**ADC Planning Consultation
Response from the Historic Buildings Adviser**

Application Number	AB/24/14/L
Address	12 High Street Arundel BN18 9AB
Description	Application for Listed Building Consent for the change of use of Flats 1 & 2 from domestic residential (C3 Dwelling House) to commercial use (A1 Shops).
Case Officer	Anita Gardner
Site Visit	Previous

Drawing Name
Plans - Proposed

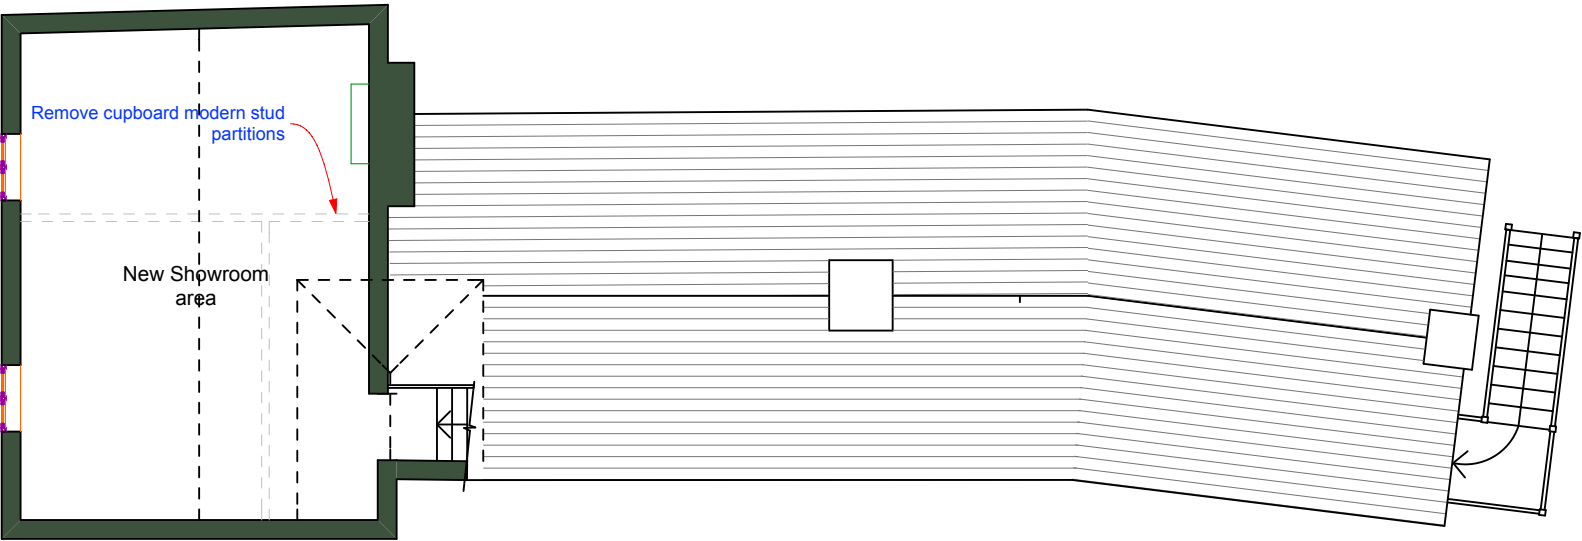
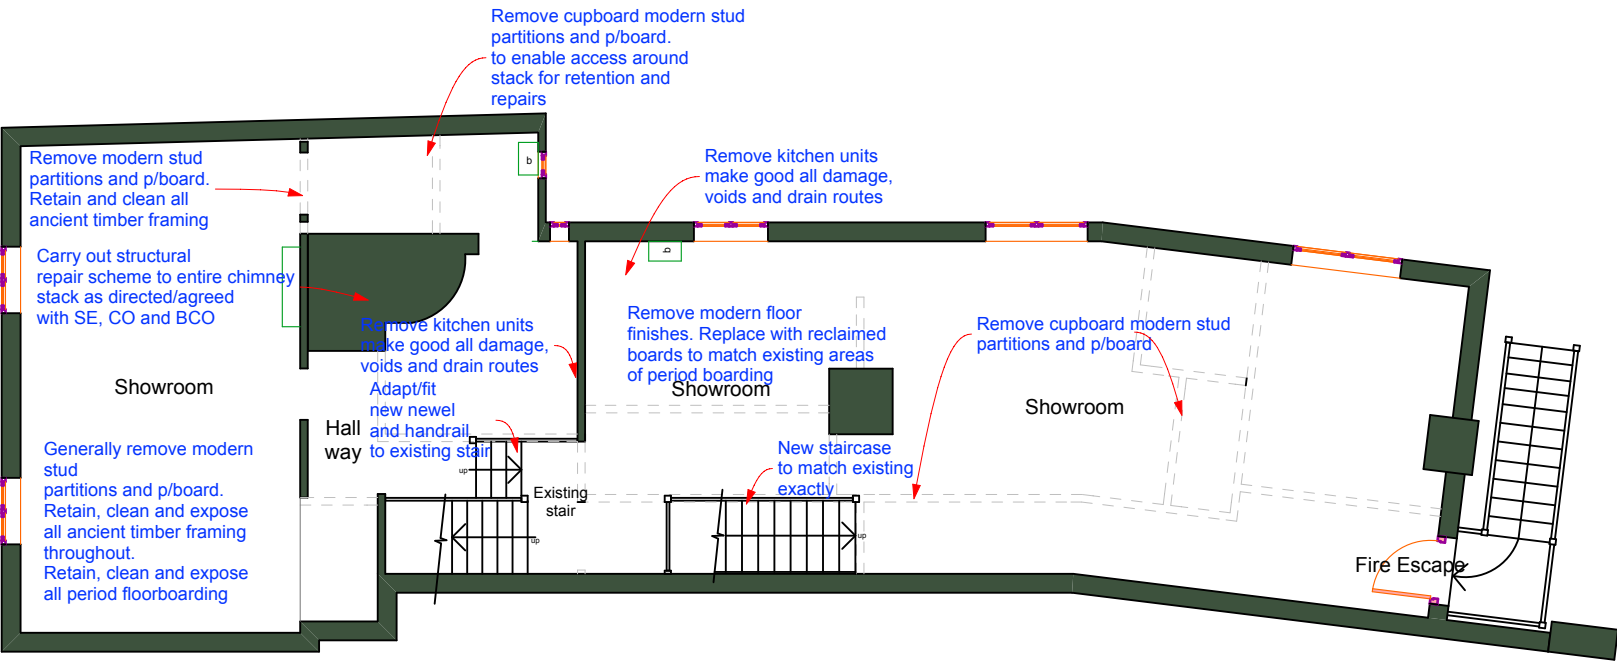
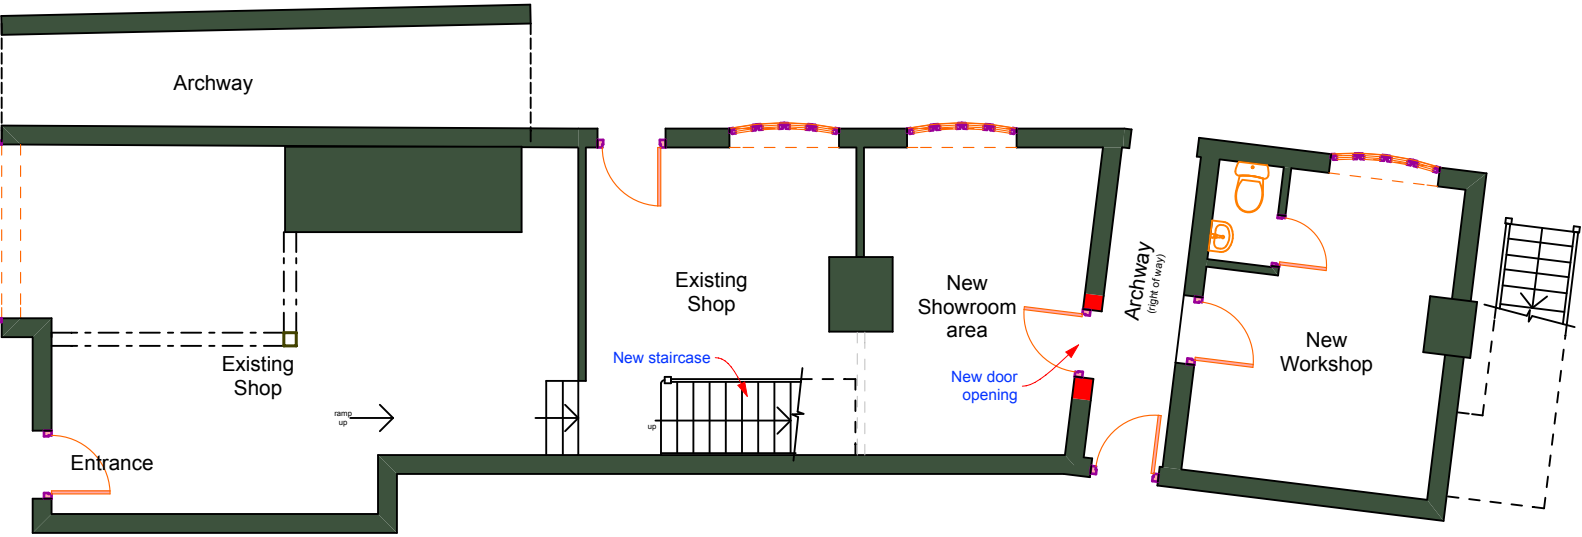
This scheme is generally acceptable, though we would recommend that the removal of the wall and the doors on the ground floor retains nibs to show evidence of the partition.
